KITTITAS COUNTY

MEMORANDUM

TO: Dan Valoff, Community Development Services
FROM: Christina Wollman, Planner II *cw*
DATE: June 13, 2011
SUBJECT: Burr Short Plat SP-11-00002

SP-11-XXXX

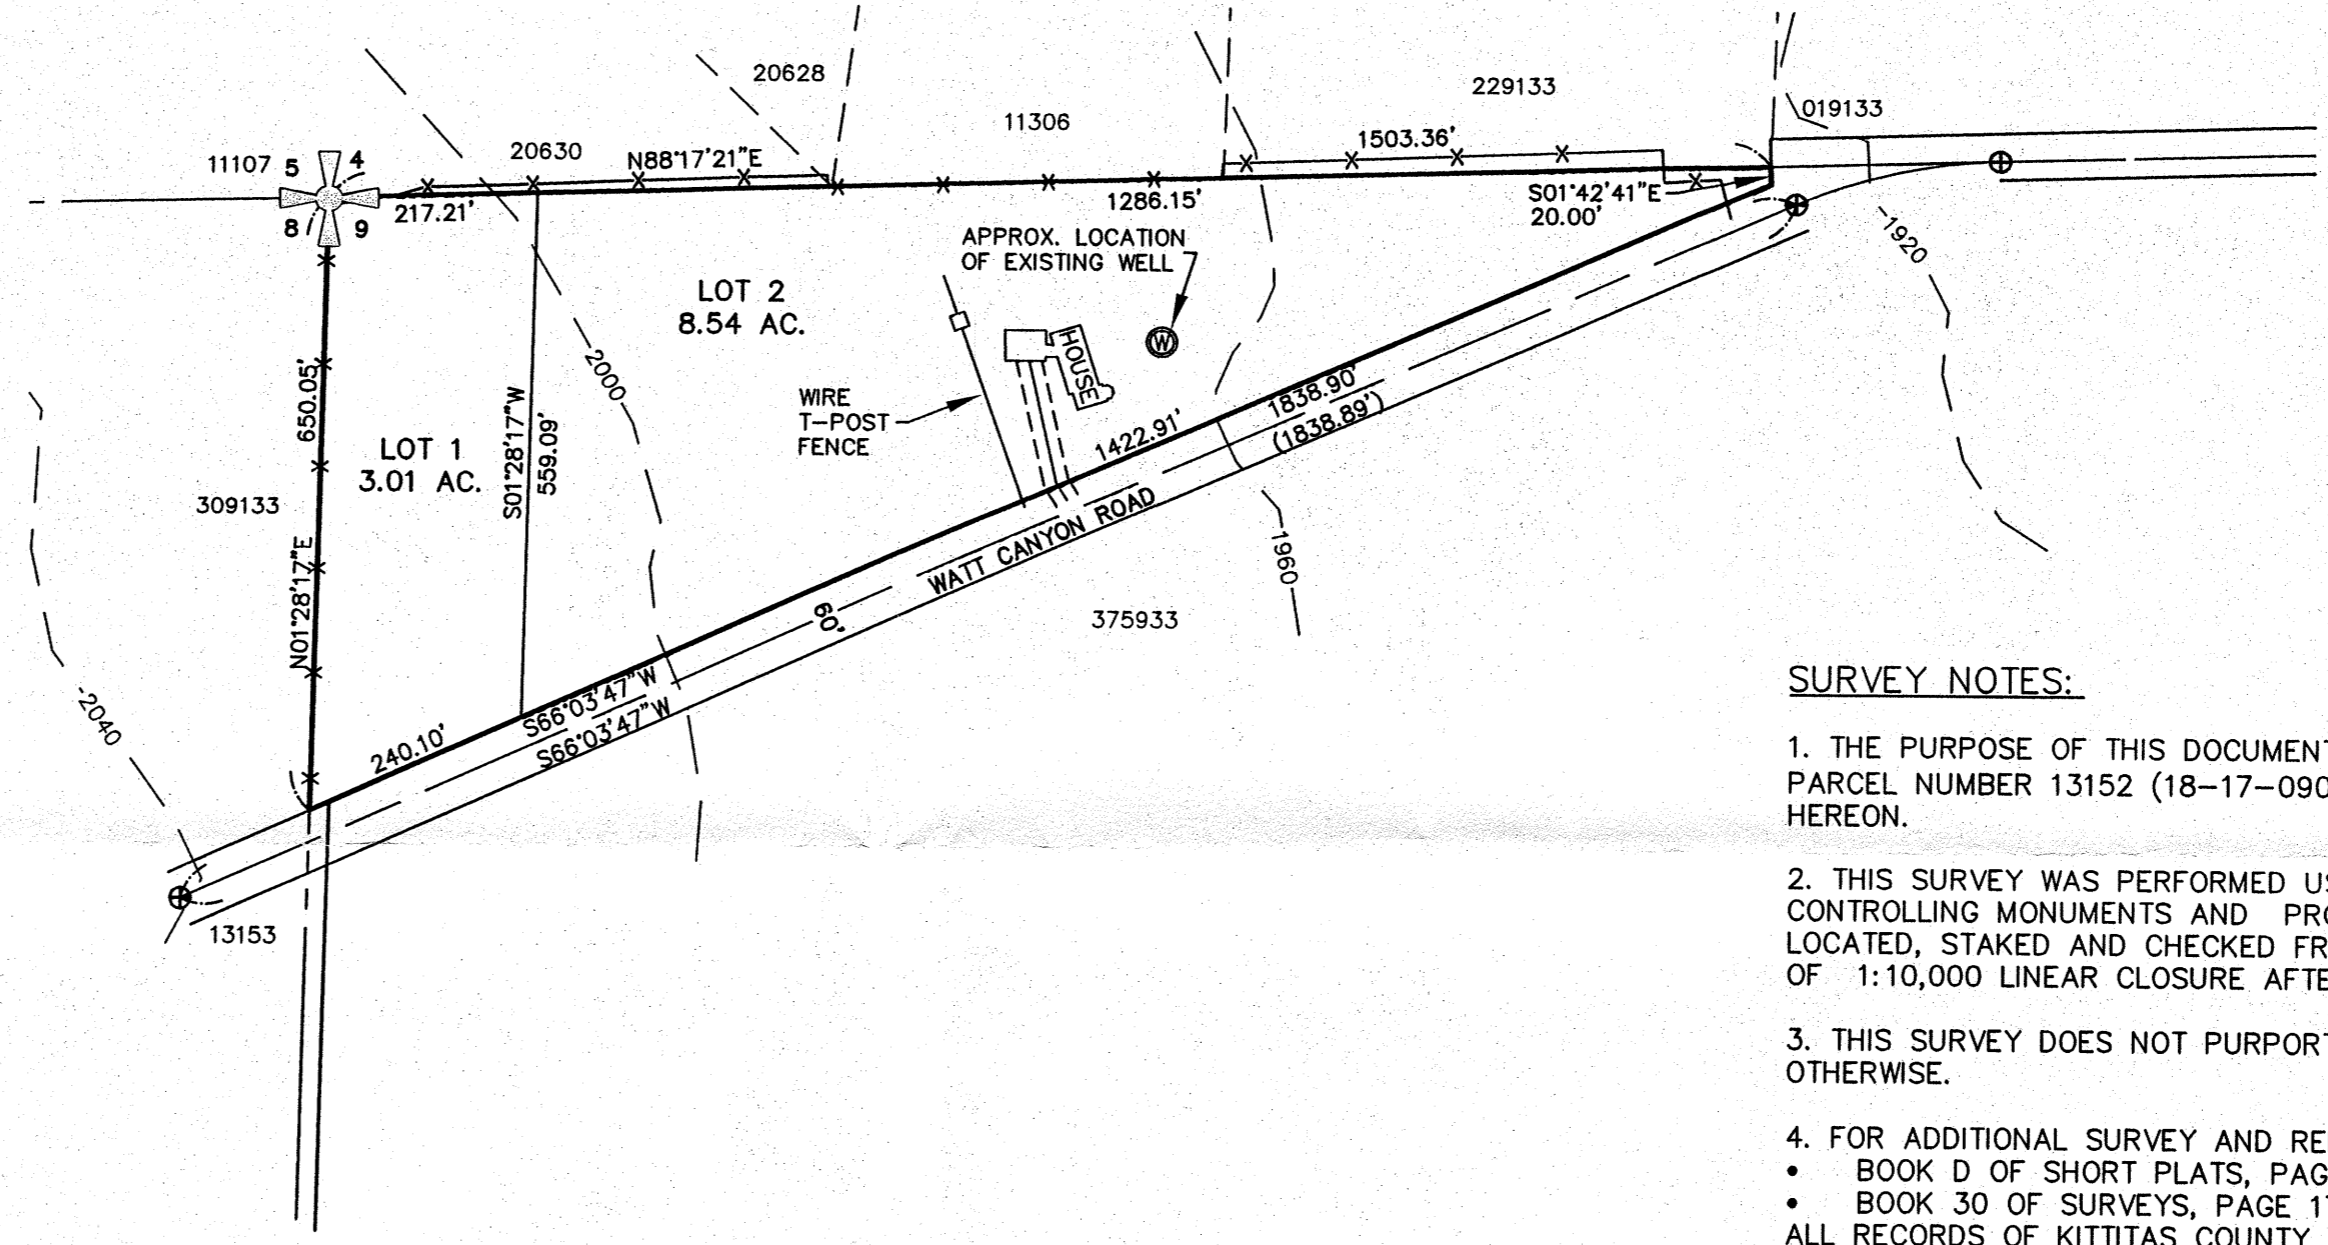
1. Access Permit: An approved access permit shall be required from the Department of Public Works prior to creating any new driveway access or performing work within the county road right of way.

2. Single-Use Driveway: A single-use access shall serve no more than one lot. See Kittitas County Road Standards, 9/6/05 edition.
 - a. The roadway shall be a minimum of 8' wide with gravel surface.

- b. Maintenance of driveway approaches shall be the responsibility of the owner whose property they serve. The County will not maintain accesses.
 - c. Any further subdivision or lots to be served by proposed access may result in further access requirements.
